**A303 Sparkford to Ilchester Dualling  
PINS Reference: TR010036**

**Comments of the draft Development Consent Order 2019**

**Submitted by South Somerset District Council  
on 1 May 2019**

WORK NO.85 HAZLEGROVE
JUNCTION EASTBOUND ON-SLIP

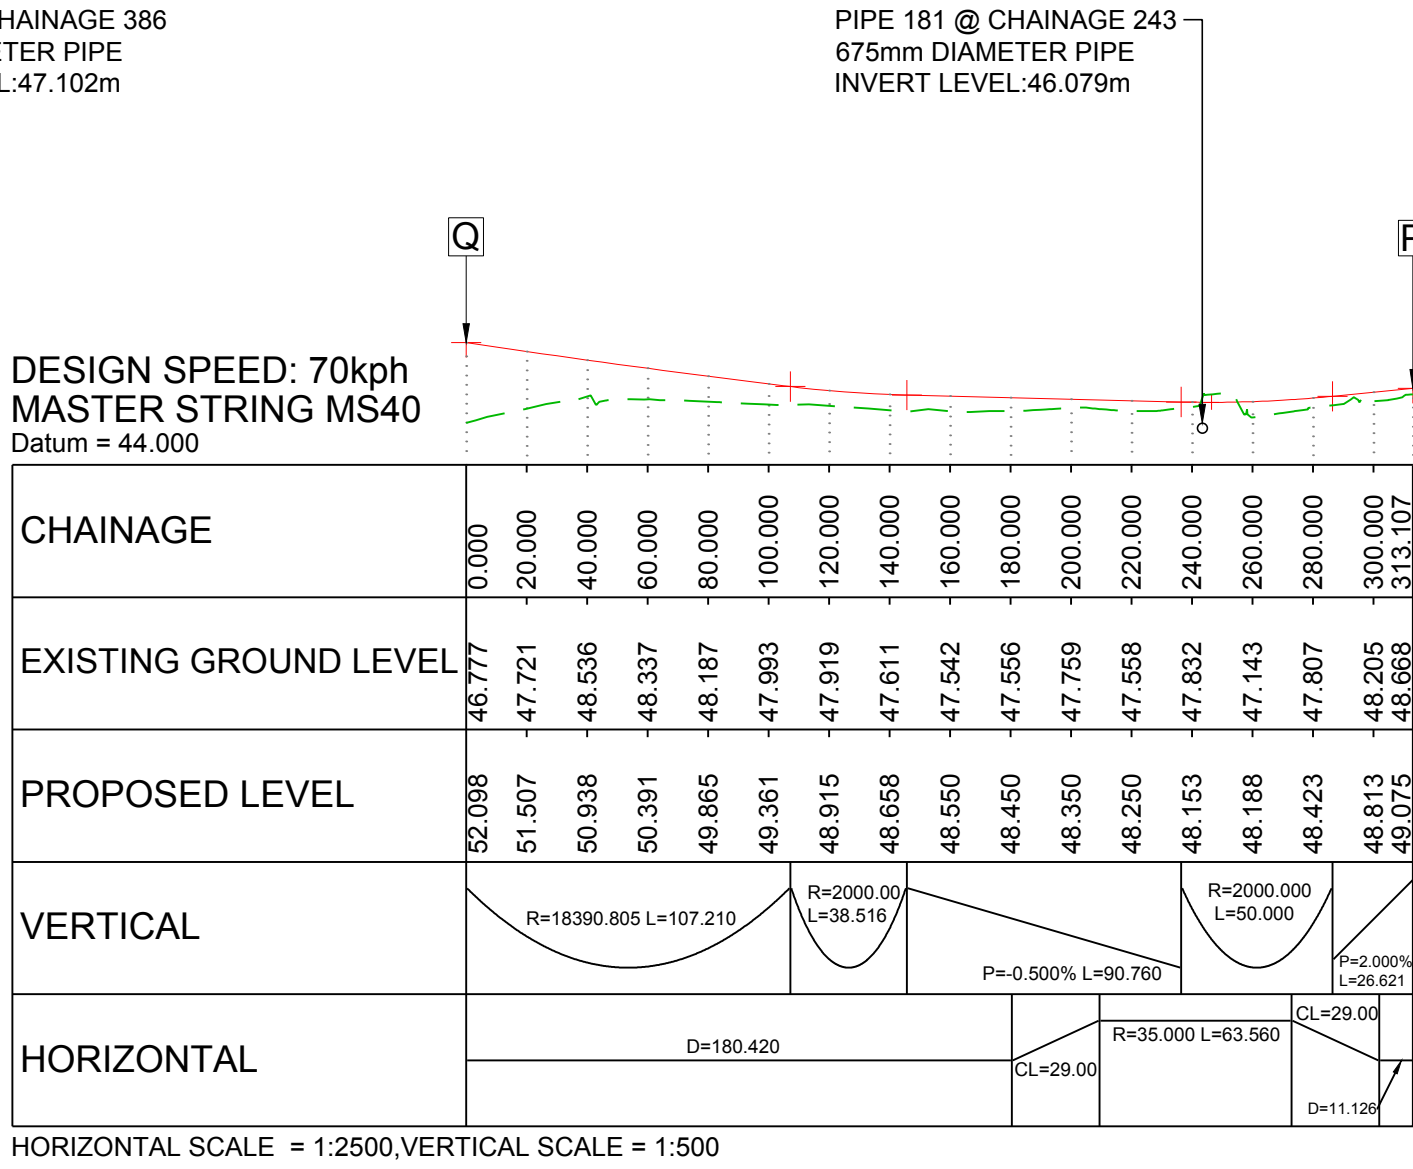
4	Article 8	<p><u>SSDC Issue</u> A 1m Vertical Limit of Deviation for the Works could render screening mitigation measures inadequate.</p> <p>An amendment to the DCO should make it clear that a variation in the vertical level should not give rise</p>	<p>SSDC’s concerns remain. The documents provided by the Applicant do not overcome SSDC’s observations concerning unsynchronised vertical adjustments between different works, i.e. a one metre fall in the height of Work No. 89 (Bund 6) alongside a one metre rise of Work No. 85 (Hazlegrove Junction Eastbound Link) would remove the two metre high bund screen.</p>

<p>to a relative reduction in height of a designed screening measure.</p> <p><u>Applicant's Position</u> Sectional drawings have been provided as confirmed in the Table of Amendments at 3.7</p>	
5	Articles 15 and 19	<p><u>SSDC Issue</u> The Applicant has included consultation with SSDC in Articles 15 and 19 however the process for the consultation needs to be reconsidered</p> <p><u>Applicant's Position</u> The applicant has accepted that SSDC should be consulted in the latest dDCO</p>	<p>Article 15 The onus should be on the Applicant to consult SSDC (not require the highway authority to consult SSDC as is currently drafted at Article 15(7)) and such consultation should take place prior to and the results be notified to the highway authority at the time the application for consent is sought under Article 15(4)</p> <p>Article 19 SSDC should be consulted by the Applicant at the same time that it consults other relevant authorities. As a result SSDC should be referred to in Article 19(4) rather than in a separate article (currently Article 19(12)).</p>

WORK NO.94 - POND 5 (SECTION 5A)

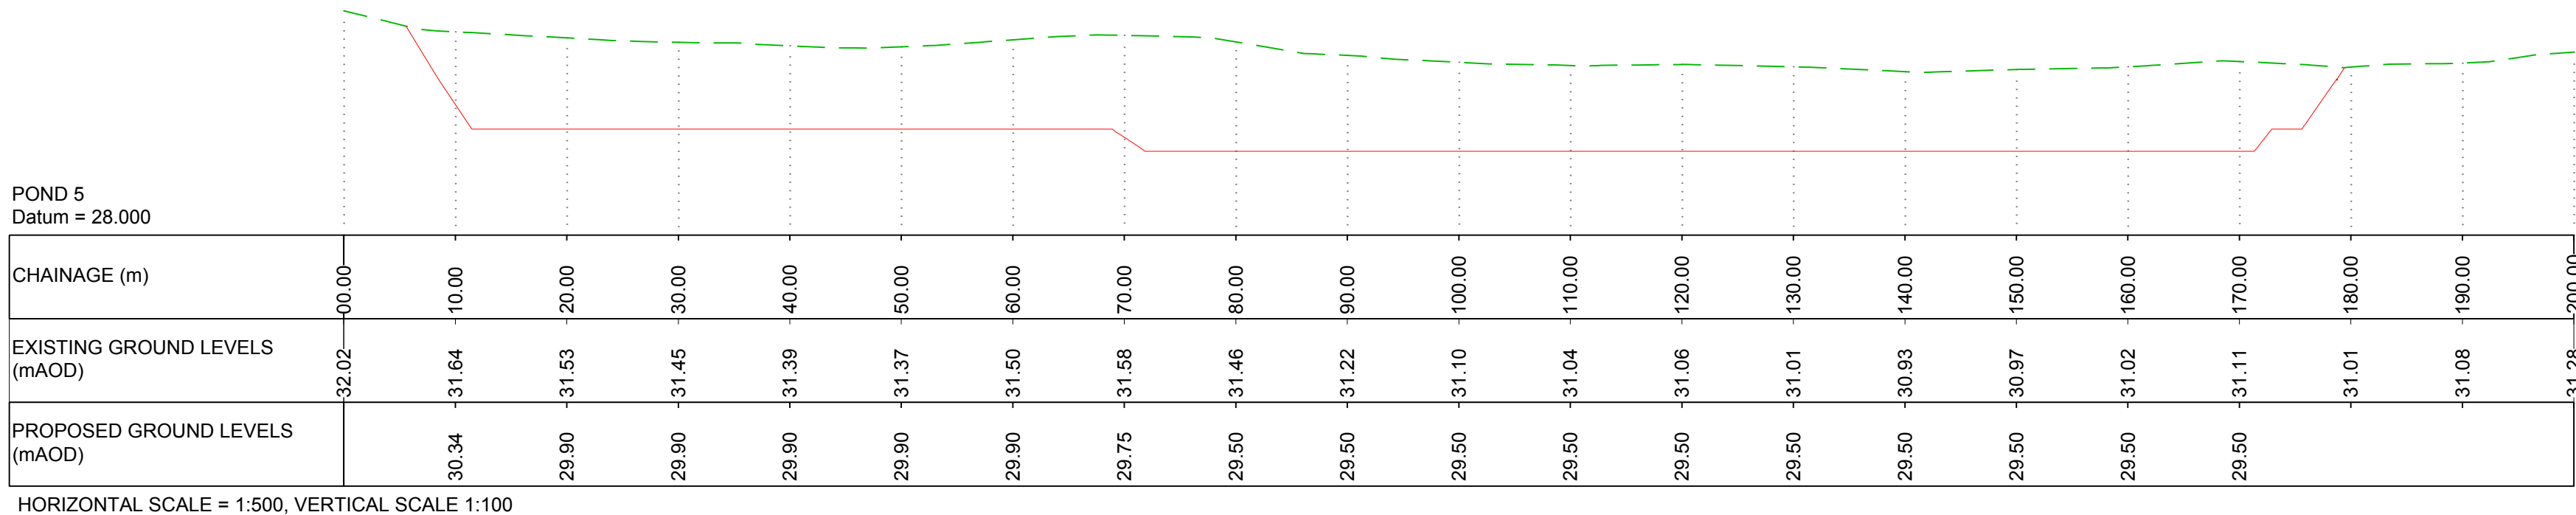
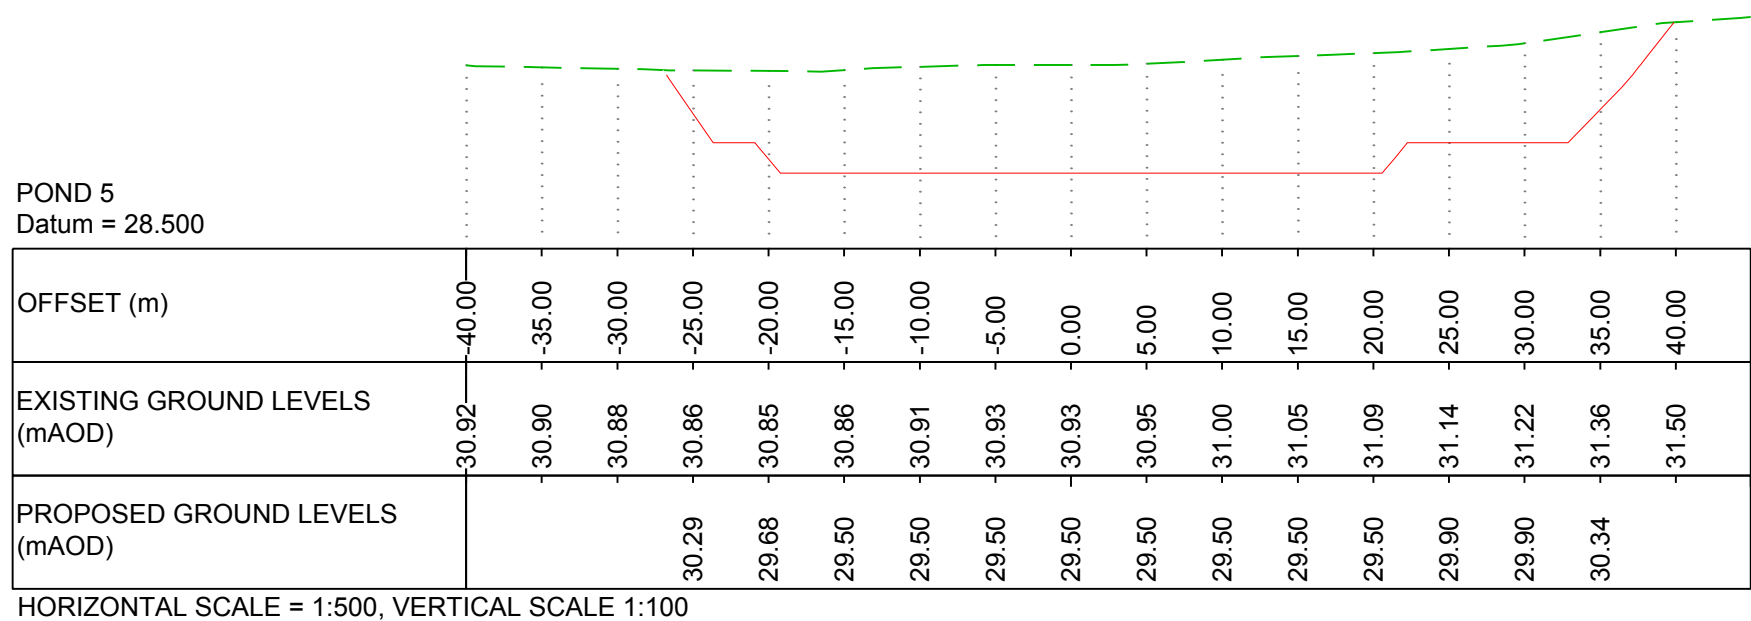
8	Schedule 1 – Authorised Development	The District Council is seeking relocation of Pond 5.	SSDC accepts changes have been made but its position remains that Pond 5 should be relocated. Discussions are currently on-going
9	Requirement 1 Definition of HEMP	<p><u>SSDC Issue</u> The wording of the definition should be more precise insofar as the HEMP is to be “<i>developed towards the end of the</i></p>	Council concerns remain that there is no provision for approval of the HEMP; as this document will effectively replace the CEMP and be the basis upon which any enforcement action can be taken the Council believes there should be consultation and approval provisions included in the DCO.
